Subject: Shoreline Exemption Permit, Pump Station 20 – 8790 85<sup>TH</sup> Ave. SE.

This is a written response to the review comments provided by the Community Planning and Development Department regarding the application for the Shoreline Exemption Permit, SHL23-006, for Pump Station 20 located at 8790 85<sup>TH</sup> Ave. SE.

INSTRUMENTATION
PUMP STATION 20 - PLAN

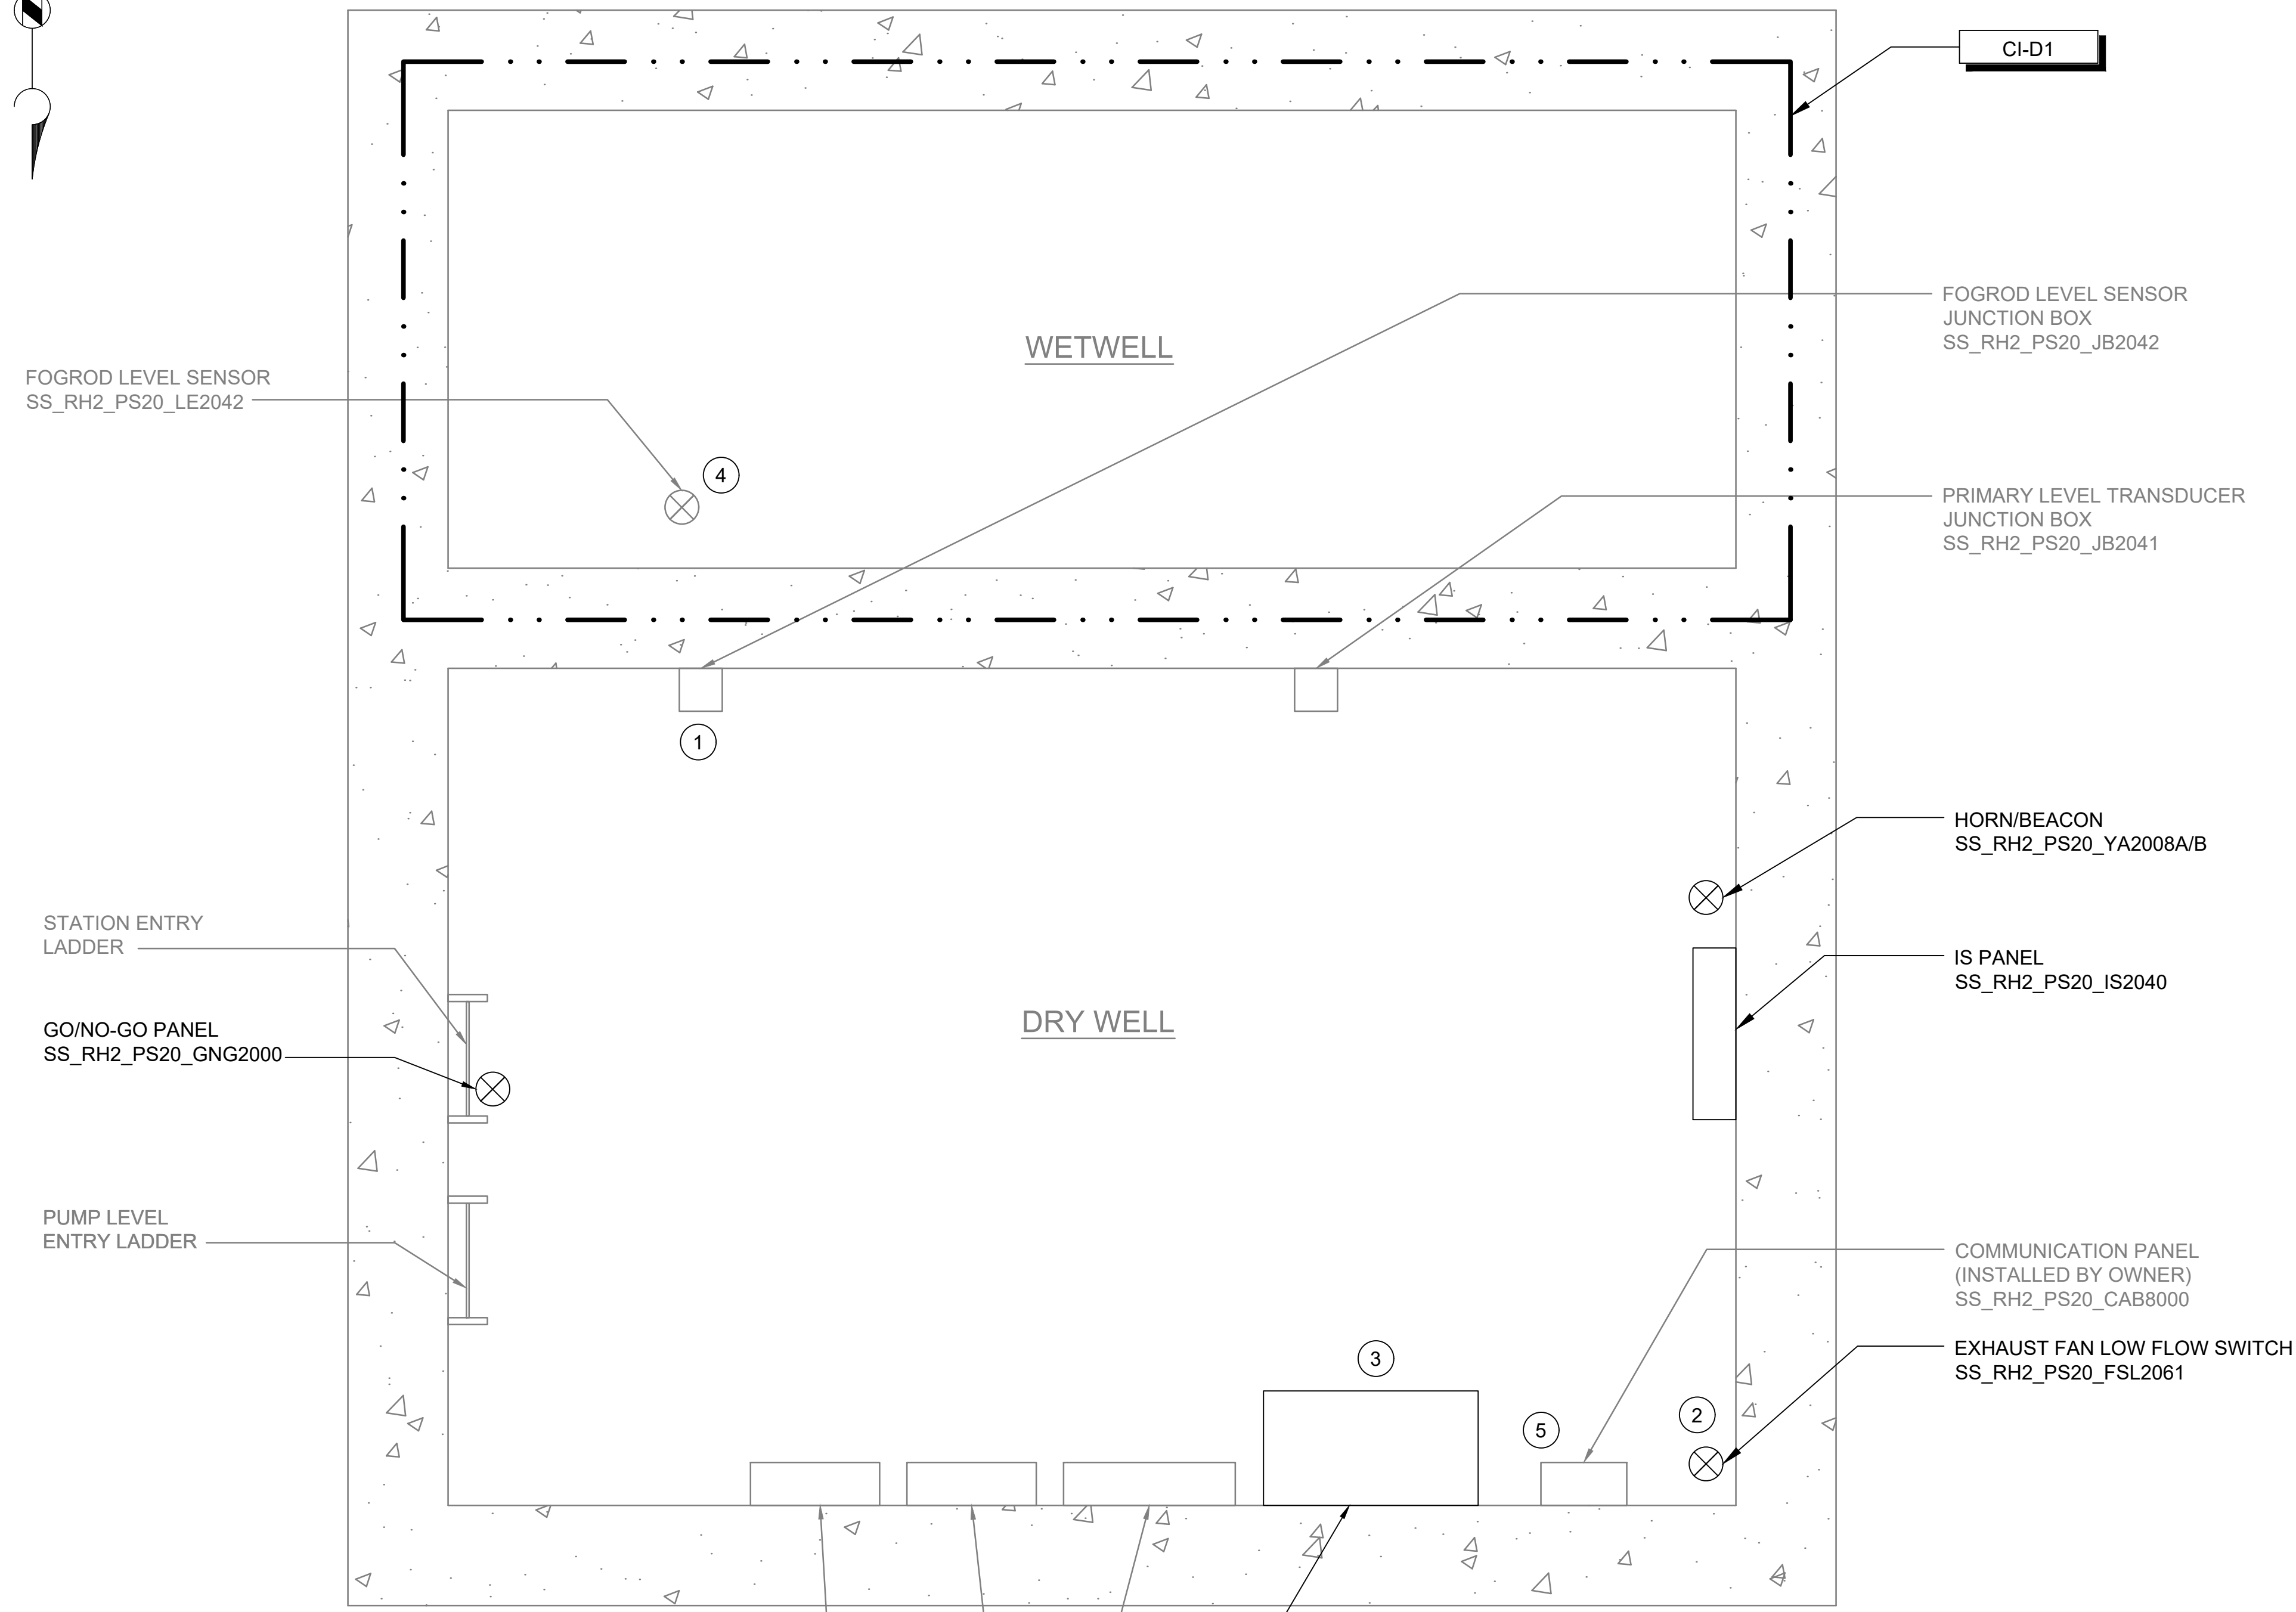
- a. Provide address of all pump stations on plans

**Response:** *The address for the pump station has been added to Development Plan, Instrumentation Drawing page 1. The address was also included in the aerial photo of the pump station.*
